Address: 80, The Knowle, Huddersfield, HD8 8EA

Application number: 2025/92776	
What is the application for?:	Outline application, with all matters reserved, for residential development with
Address of the site or building:	land at, Eastfield, Shepley, Huddersfield, HD8 8HB
Postcode:	DH7 8XL

Type of comment: An objection	
Do you wish your comments to be published on the website anonymously?	No

Figure 4-2 Knowle Park Avenue Proposed Southbound only arrangement

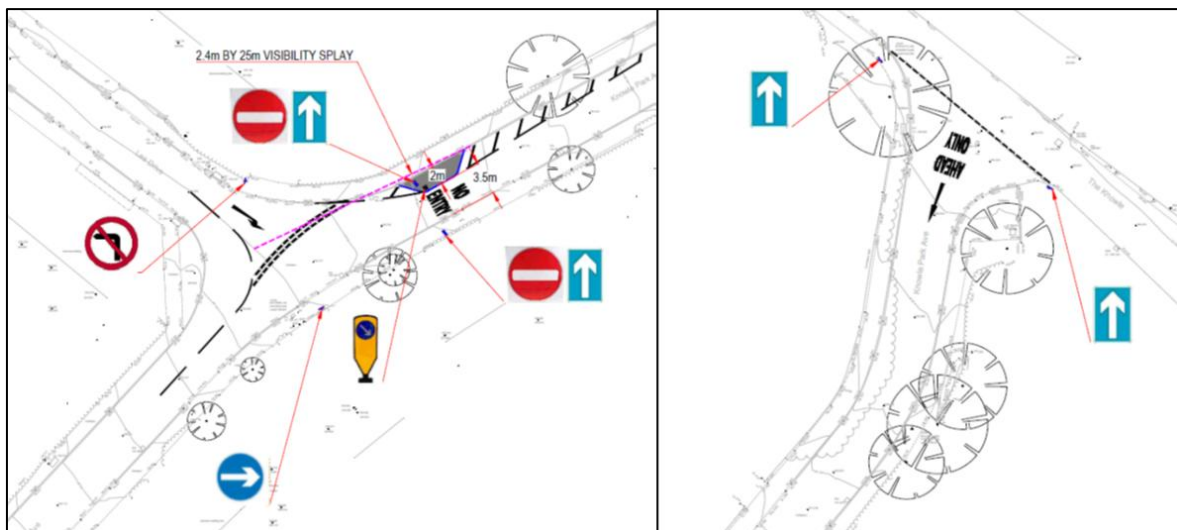
2) One way access into the development from Knowle Park Ave would lead to increased traffic turning into the Knowle from the A629, which has limited visibility and is only wide enough for a single vehicle. This would jeopardise the only safe exit for the residents of the Knowle.

Drawing:
PROPOSED HIGHWAY IMPROVEMENTS - LEA DRIVE / ABBEY ROAD JUNCTION

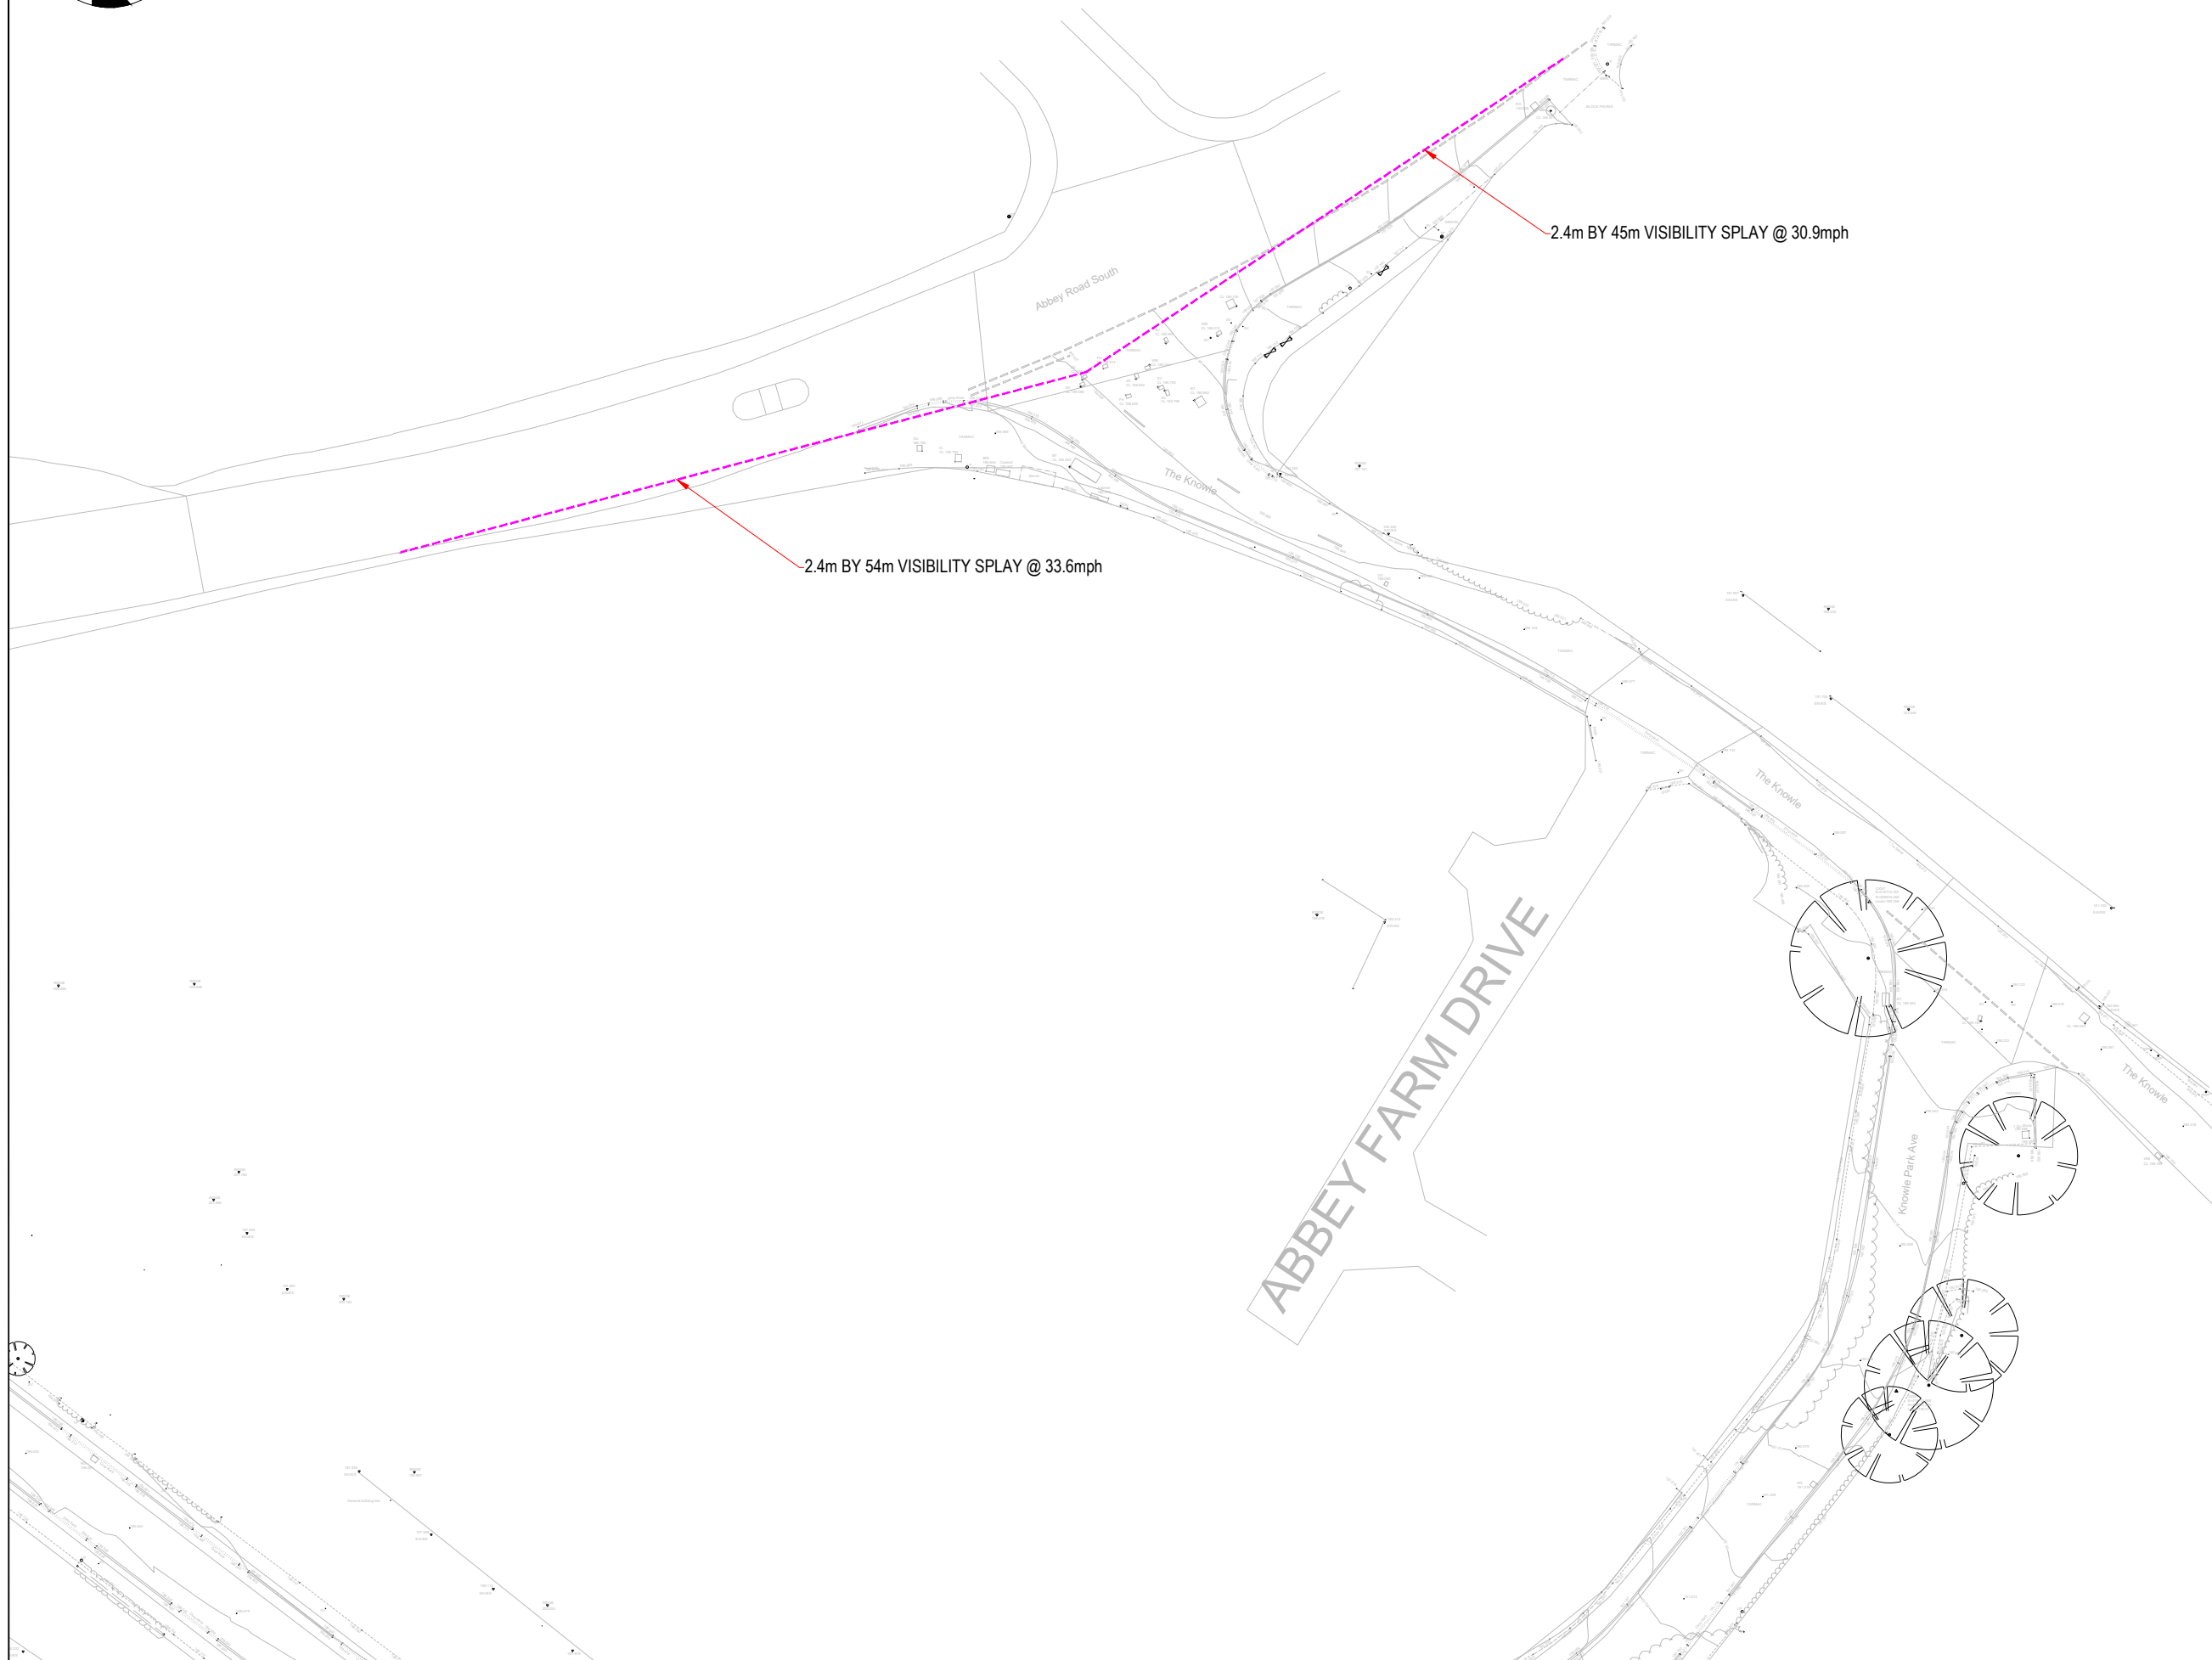
Vehicles leaving the proposed development will use Lea Drive. The final few metres of this exit are very steep around a 1 in 7 gradient, considerably steeper than the Kirklees’ maximum gradient of 1 in 15 for any new development. Under snow/icy conditions the road can become treacherous. If a vehicle lost control on the downward slope there is a very real risk that it could slide into traffic on the busy A629.
